MAJOR DEVELOPMENT PLAN AMENDMENT

PART W 1/2 SEC 1, T 13 S, R 65 W, 6th PM FALCON, COLORADO

COVER SHEET
NEW RV STORAGE FOR:
FALCON STORAGE
PART W 1/2 SEC 1, T 13 S, R 65 W, 6th PM
PEYTON, COLORADO

SHEET
SDP1.1

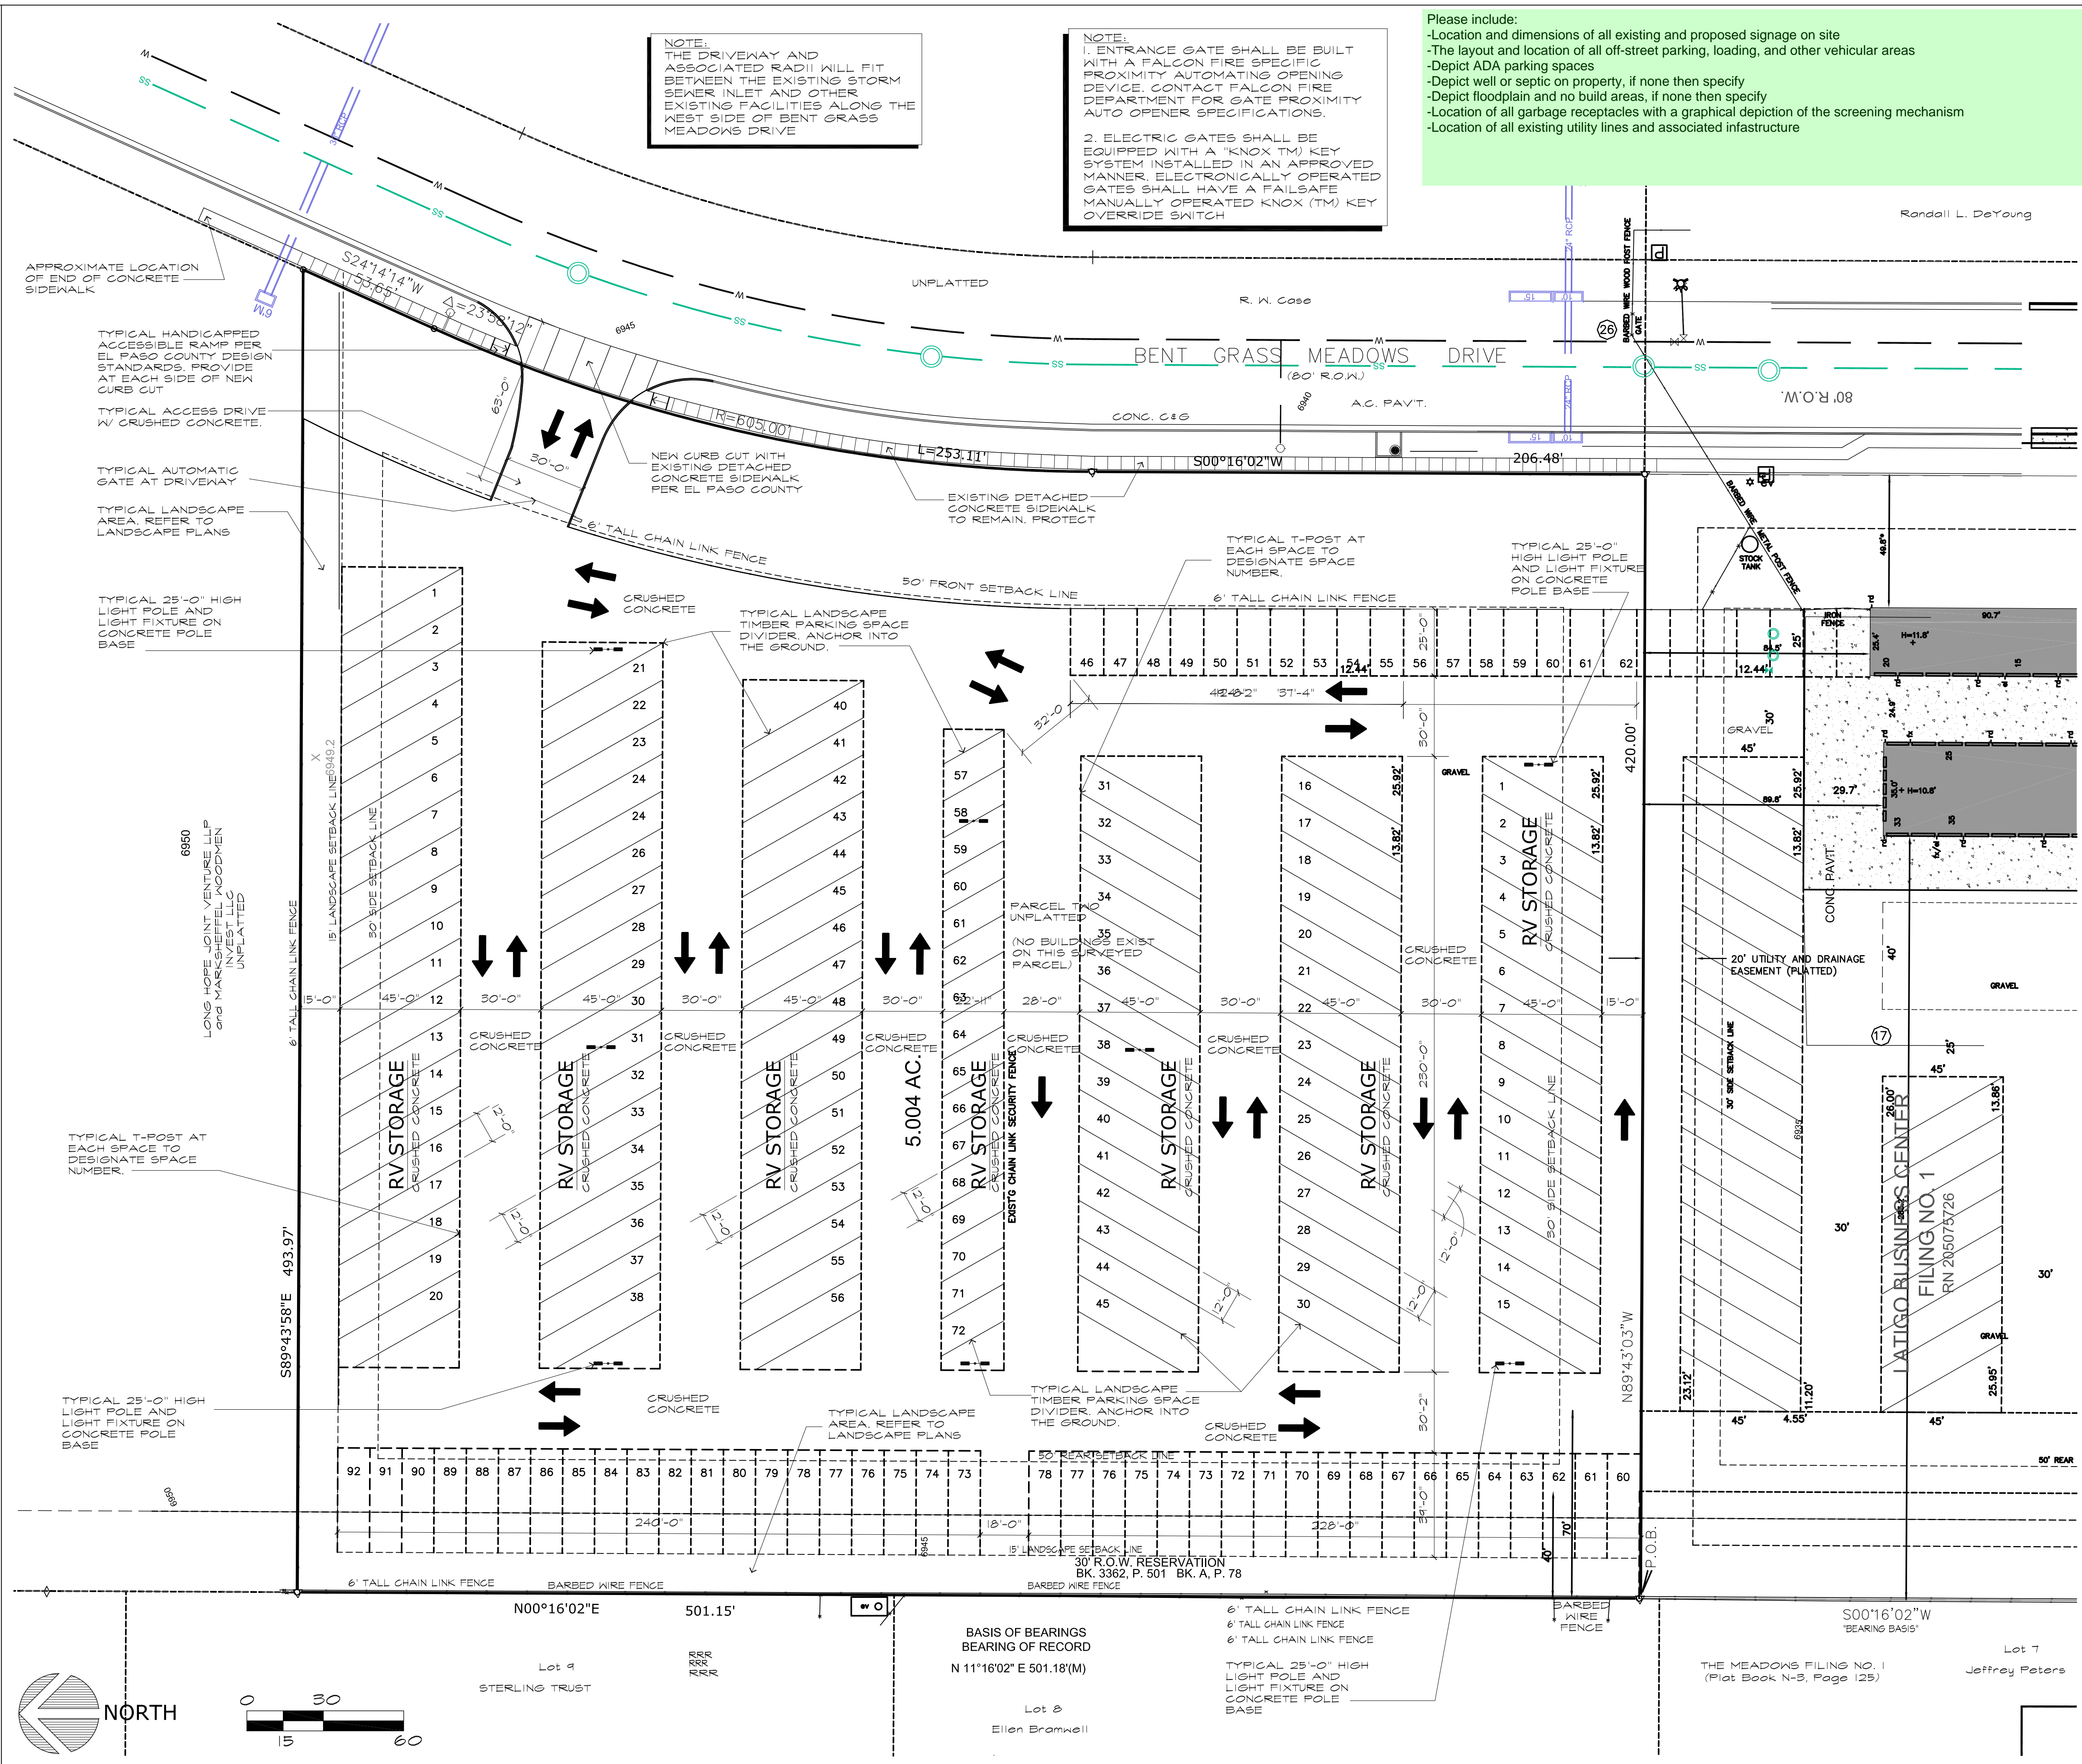
Please identify the setbacks required from Bent Grass Meadows Drive

please update the schedule

Please provide:
-total gross building square footage
-open space, landscaping, and impermeable surface percentage
-parking computations

SHEET
SDP1.2

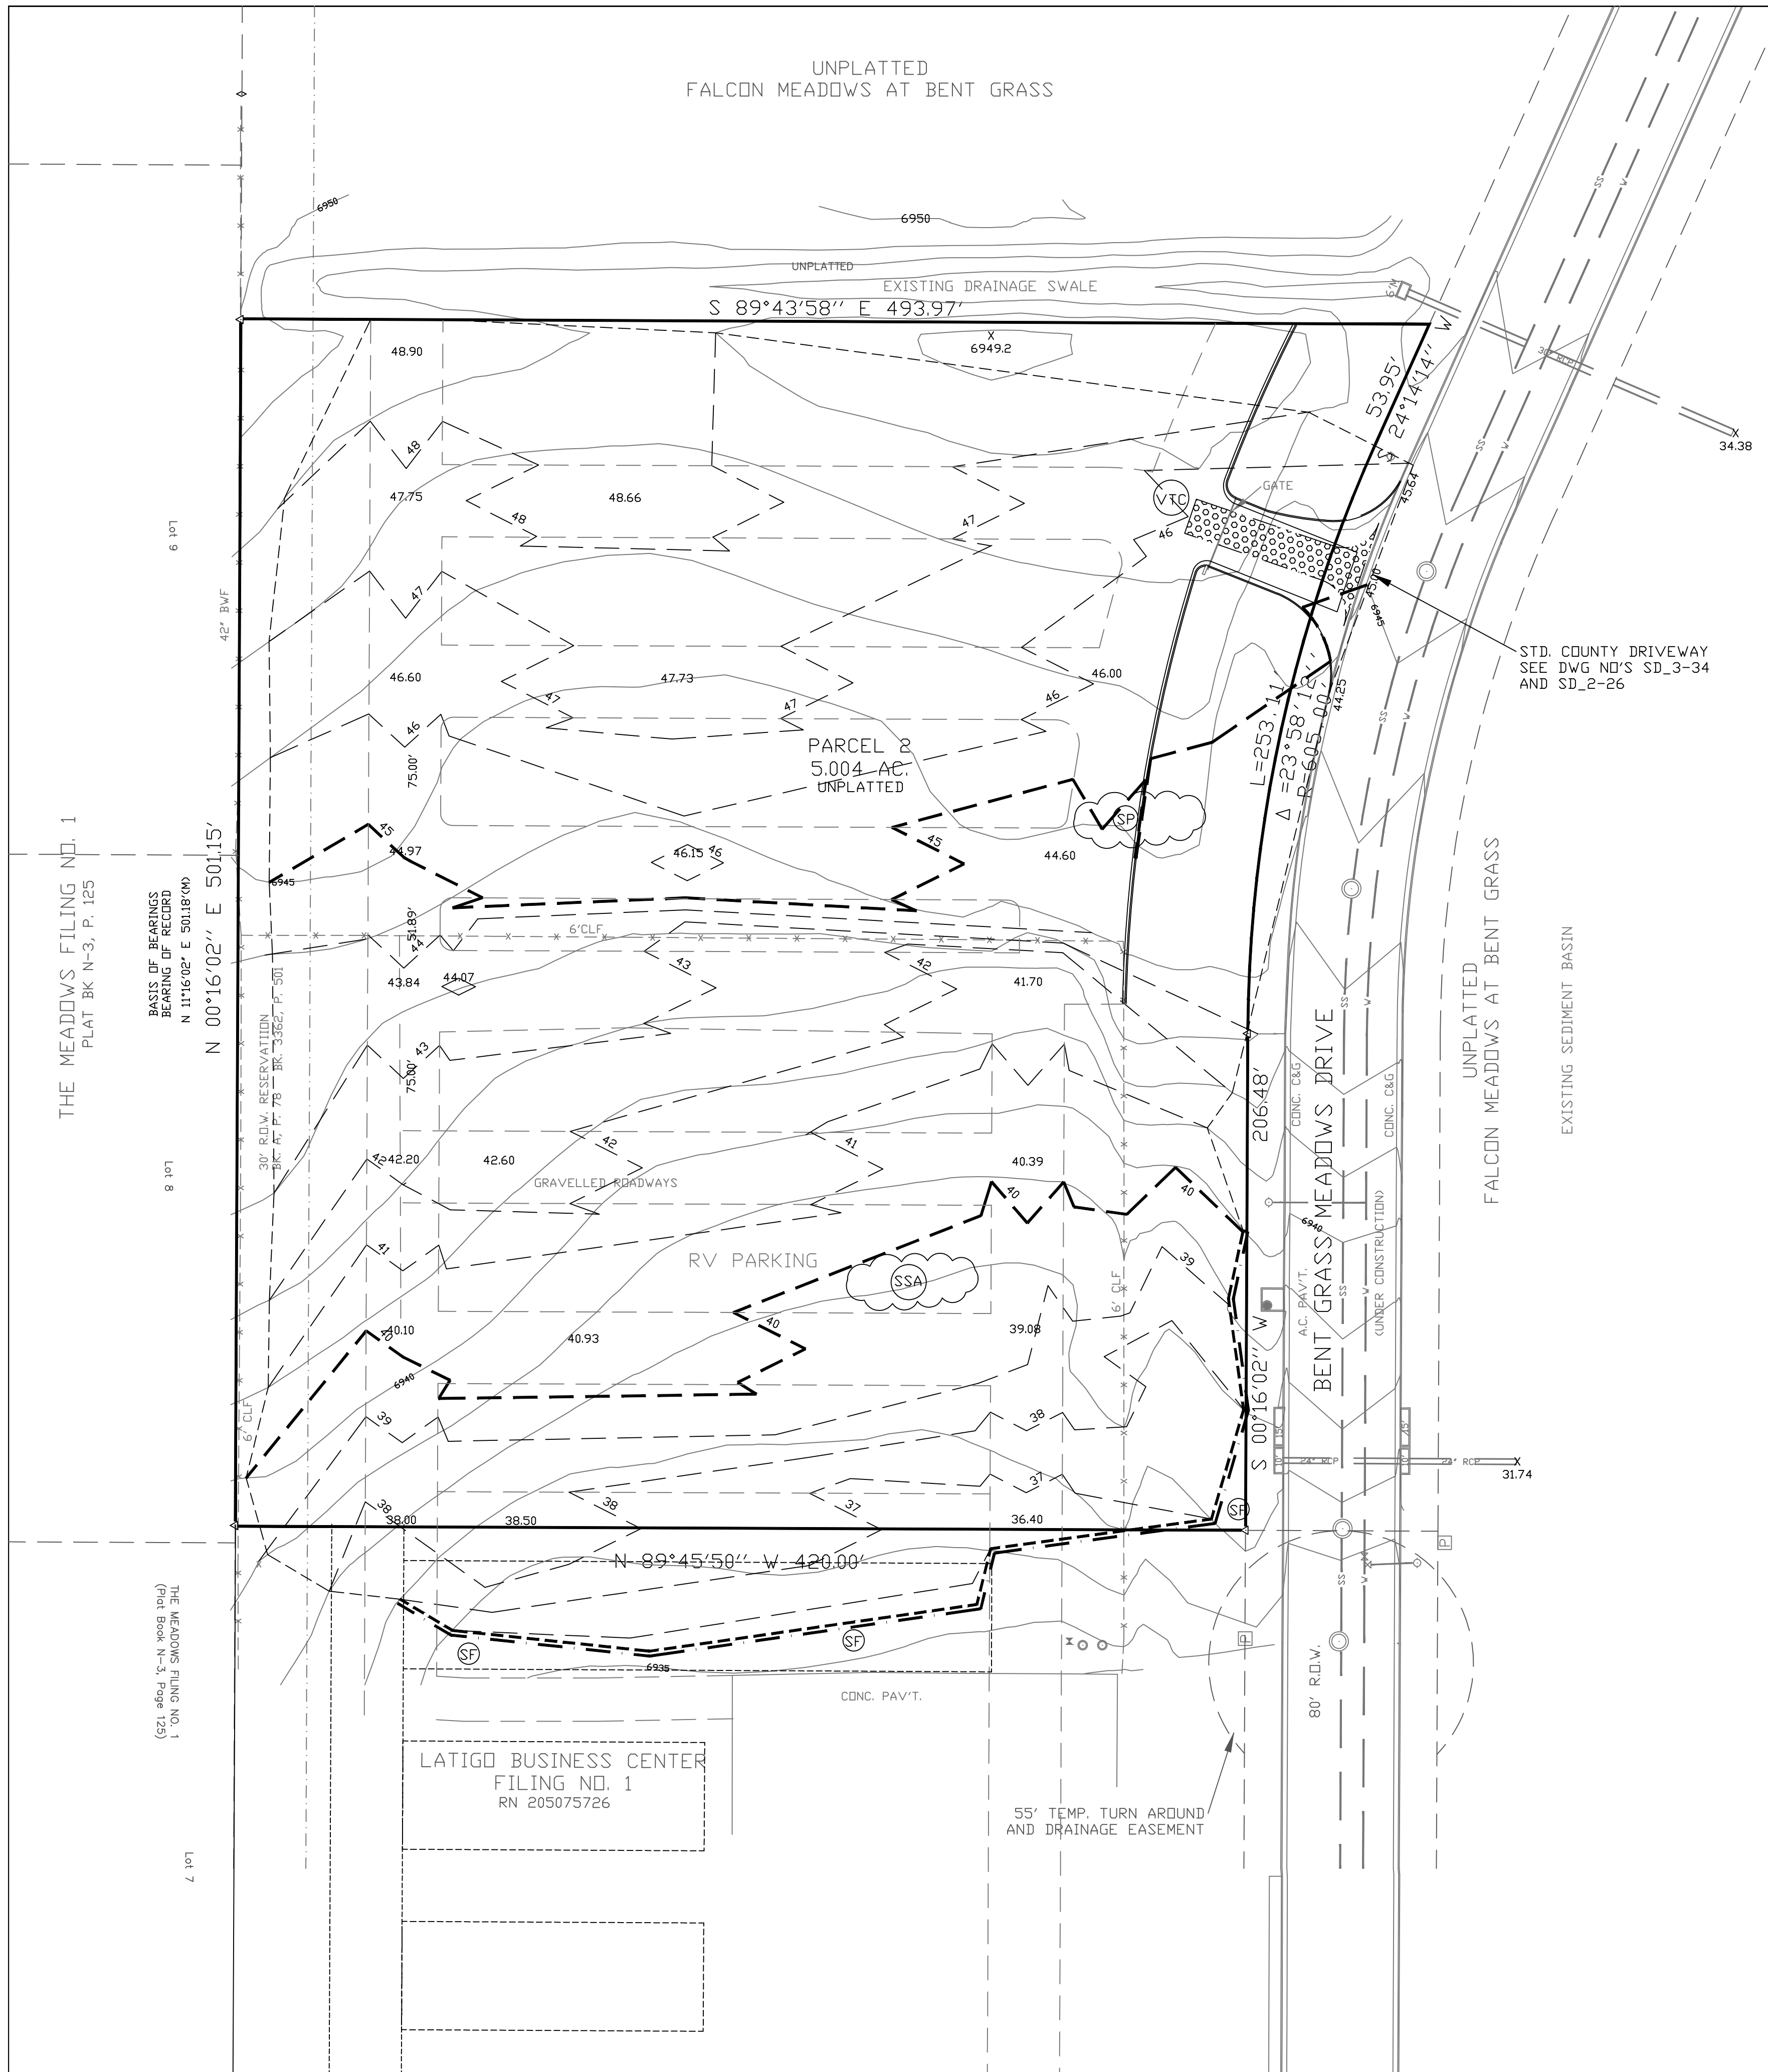
see comments on the stand
alone GEC plan submitted
